Re: Planning Application 21/0018

Address: 38 The Hazels Wilpshire BB1 9HZ

Description: Proposed single storey extension, internal alterations and garage conversion to include a new window.

ROOF & SITE PLAN SCALE 1:200

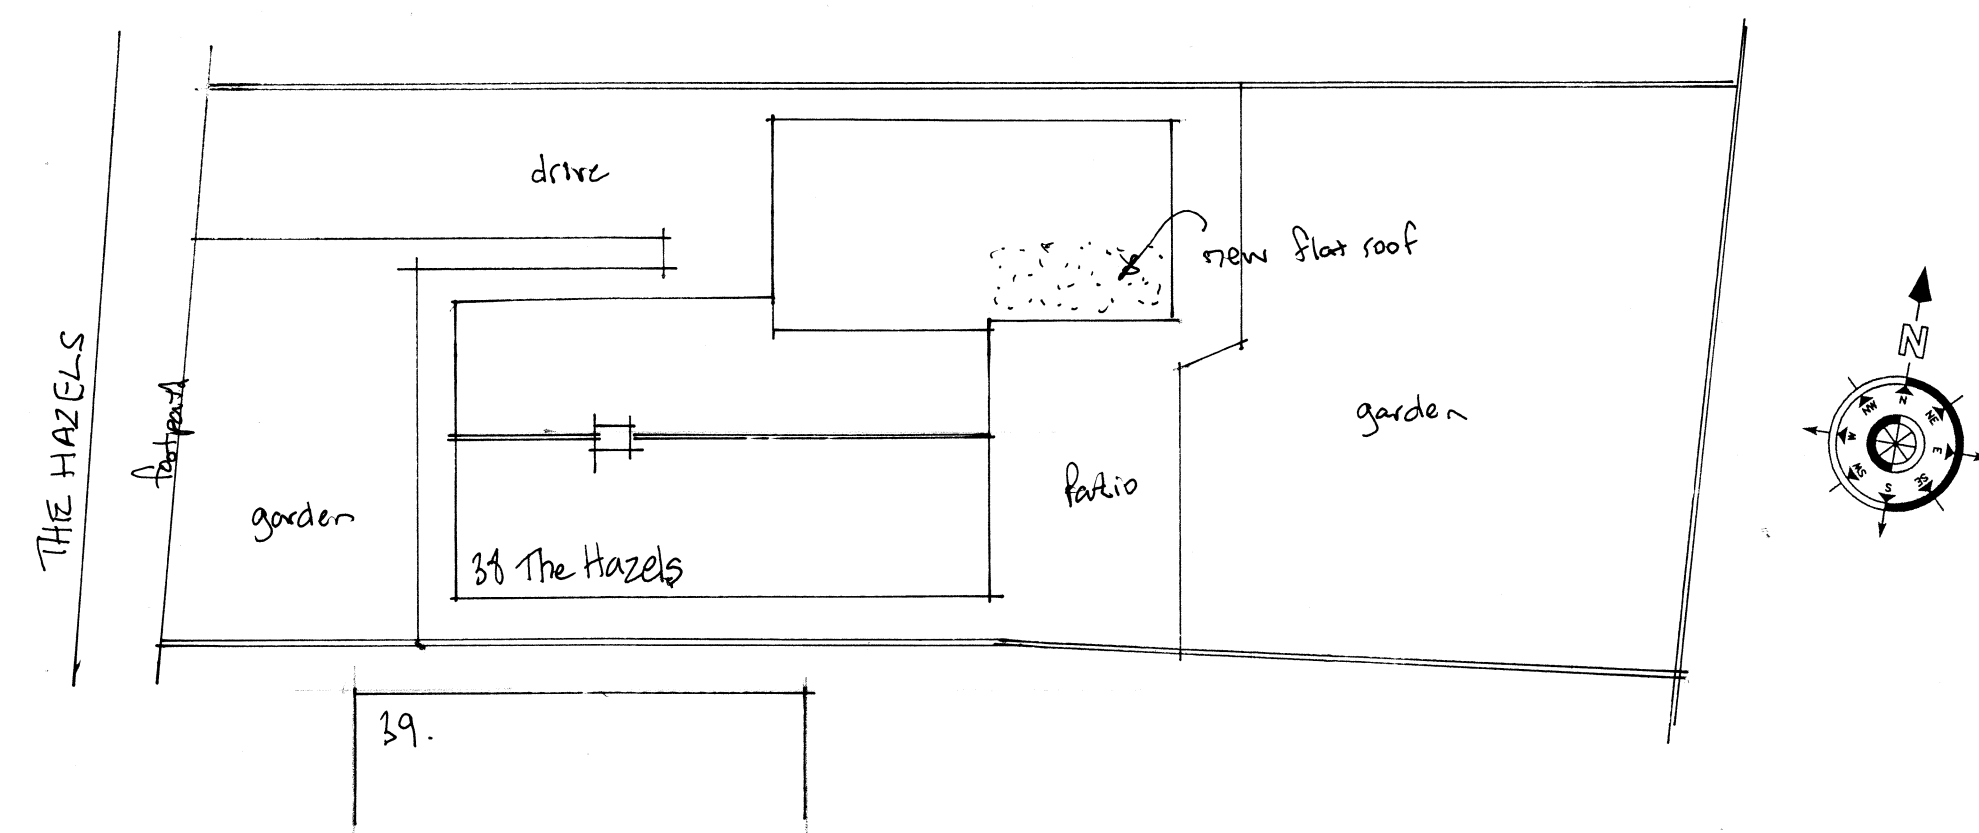
With respect to this application we would not raise any objections to the application. Whilst a plan has not been provided it is expected that there will be sufficient space to allow for 2 off street car parking spaces.

All garage or driveway facilities shall include provision of an electrical supply suitable for charging an electric motor vehicle.
